CITY OF ALBUQUERQUE

January 4, 2018

RE: De Anza
Grading Plan and Drainage Master Plan
Stamp Date: 12/13/17
Hydrology File: K17D106

CD2

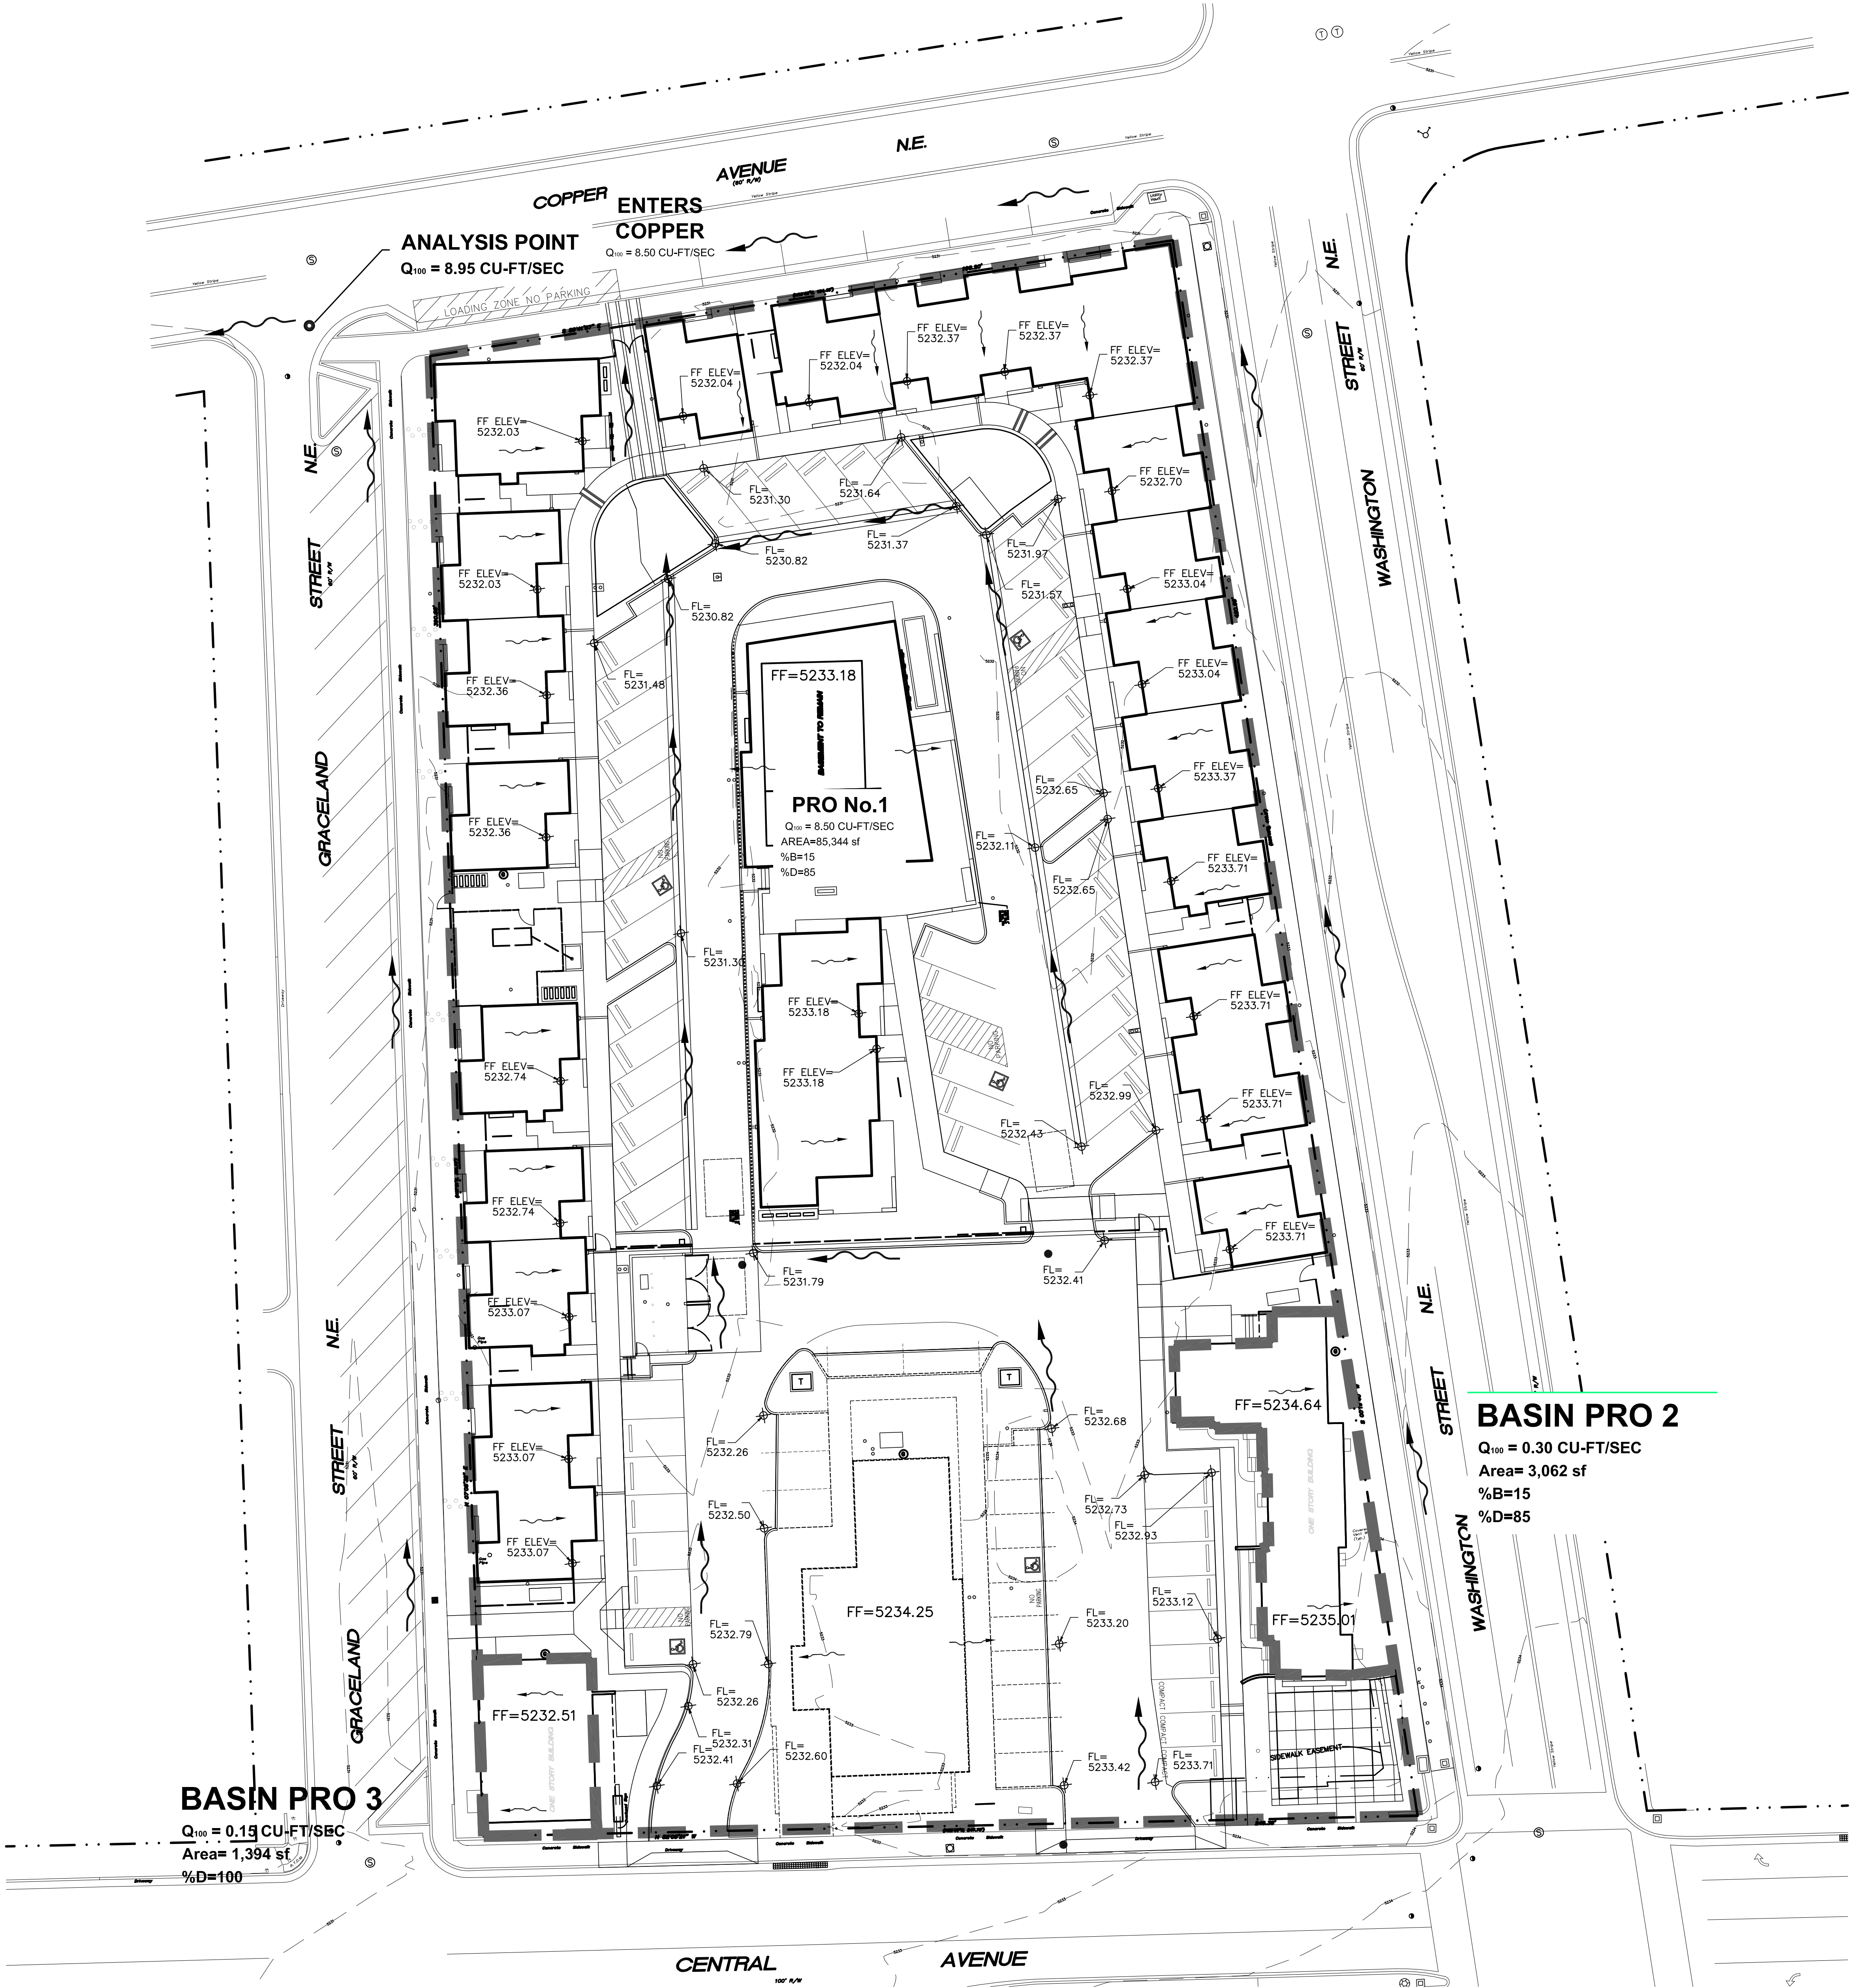
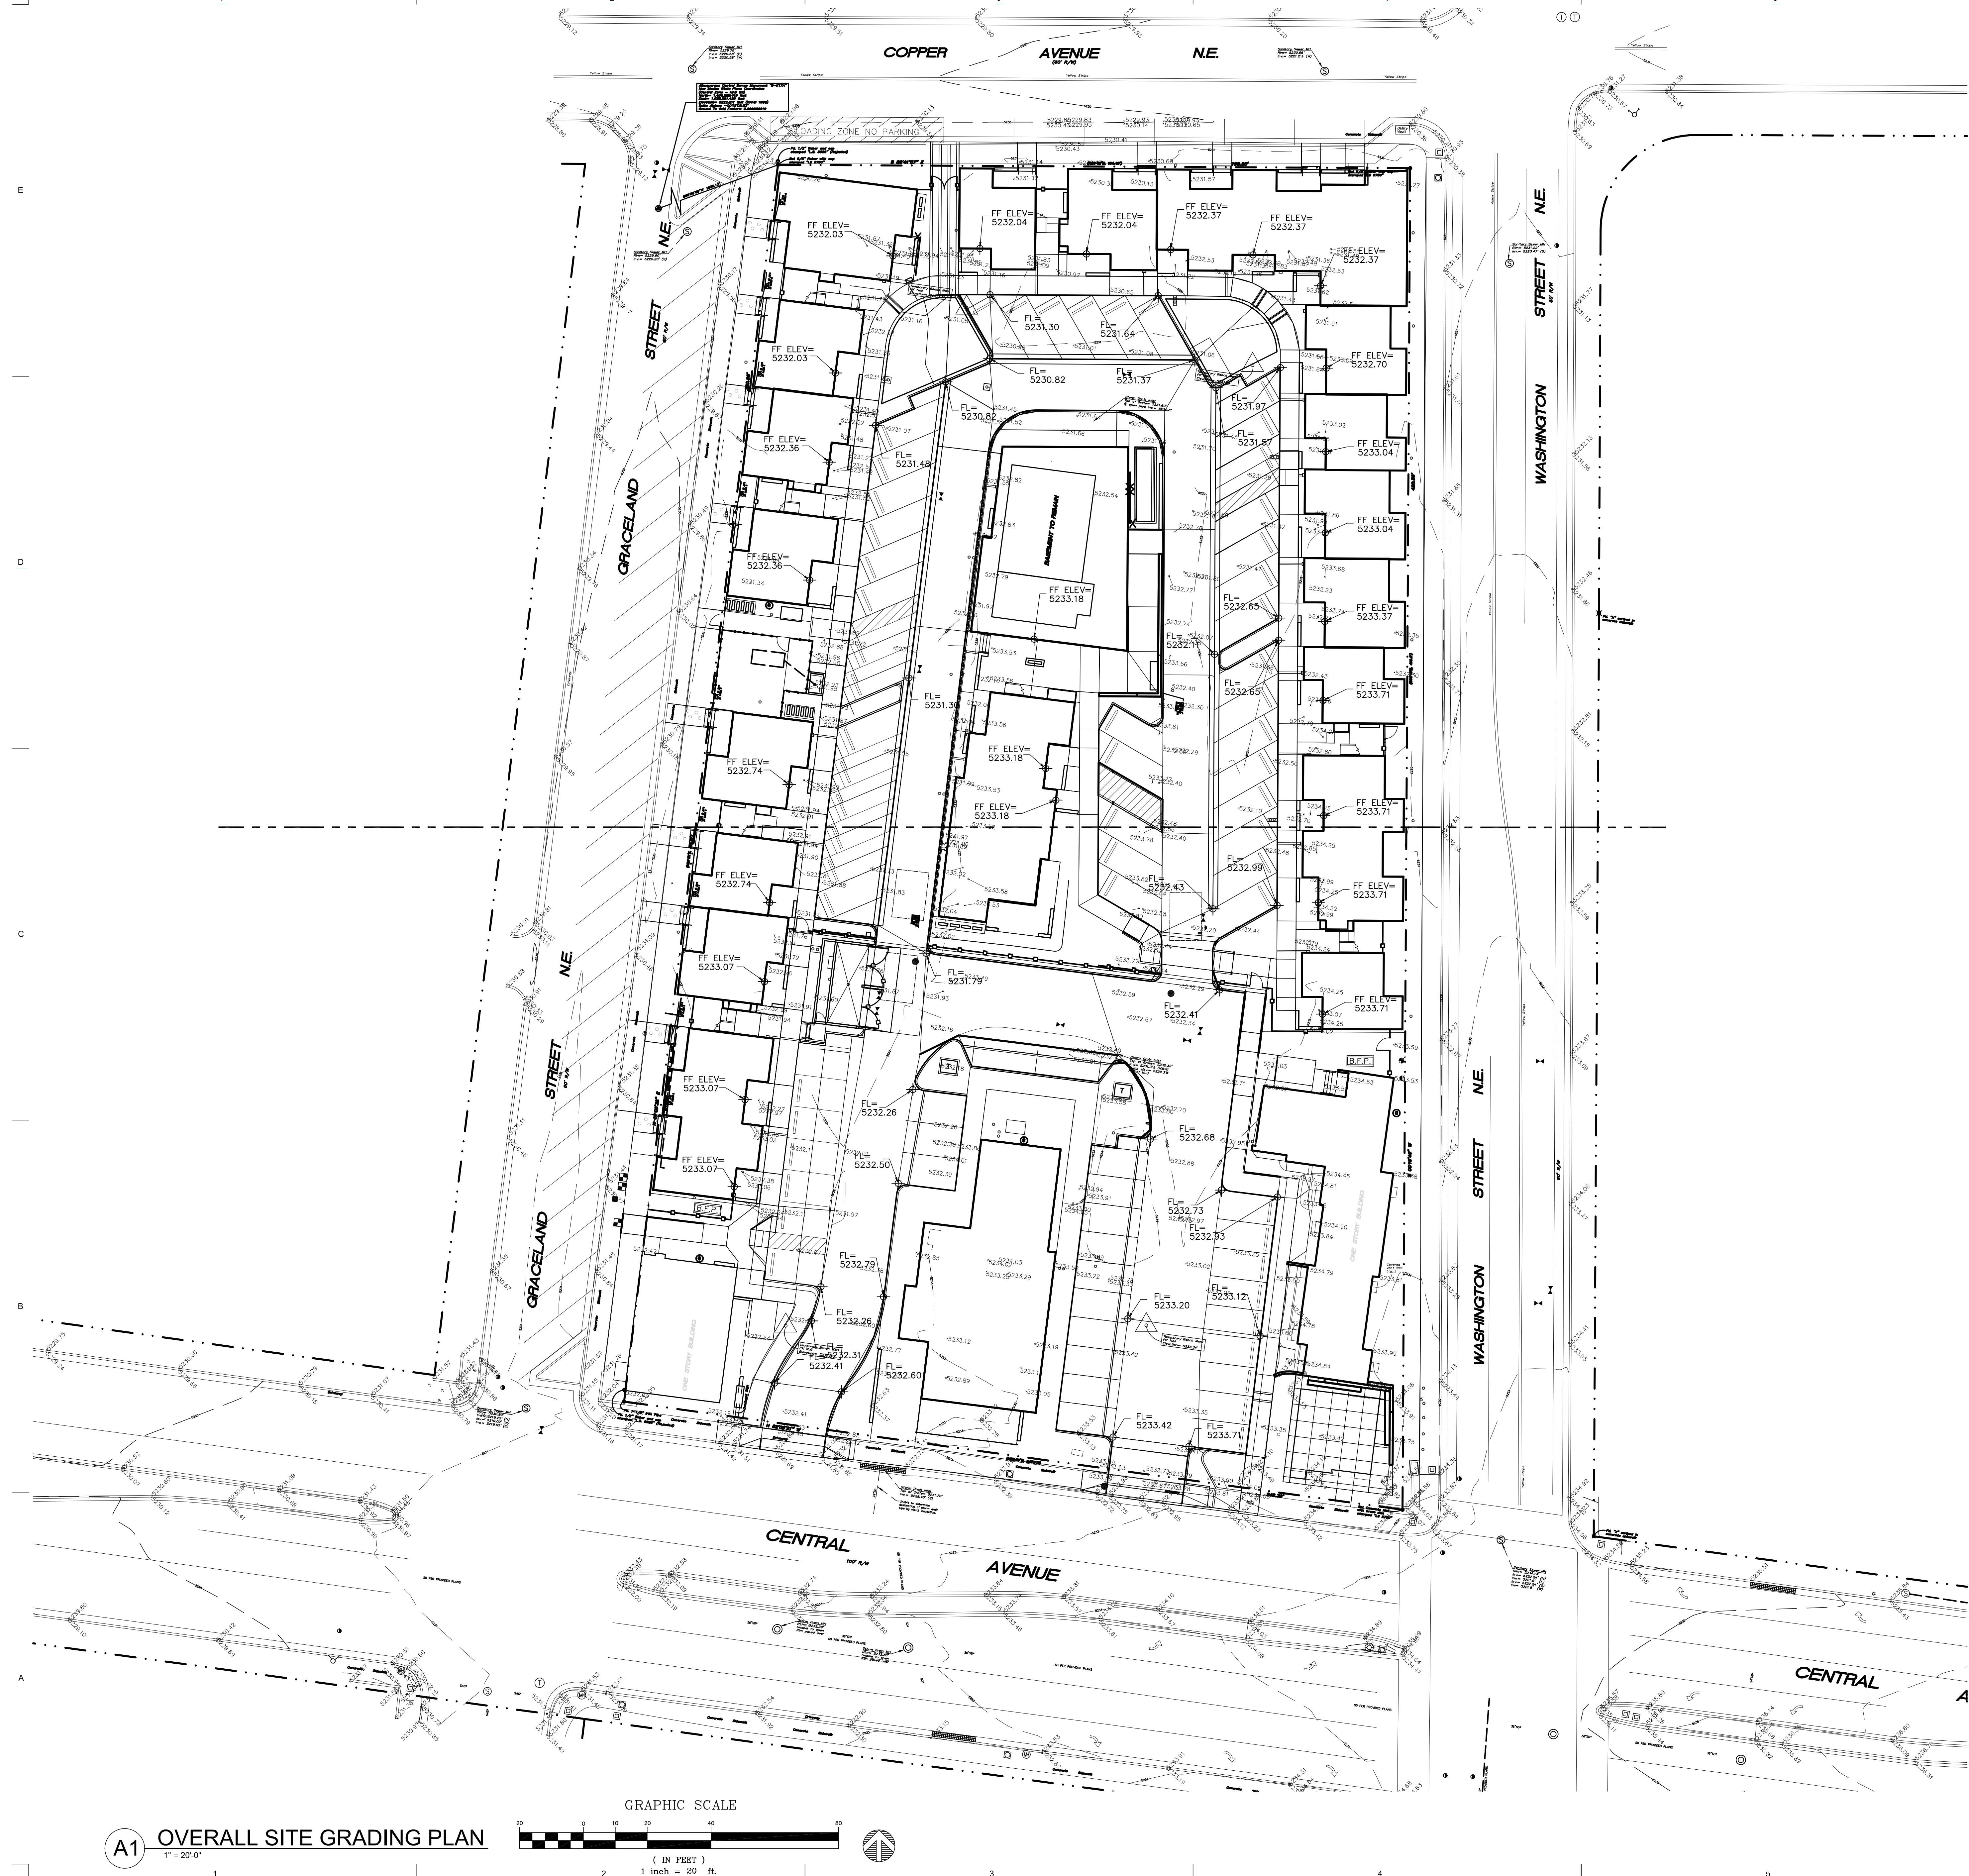
1. Sheet CD1 & CD2. Please provide an engineer's stamp with a signature and date on sheets.
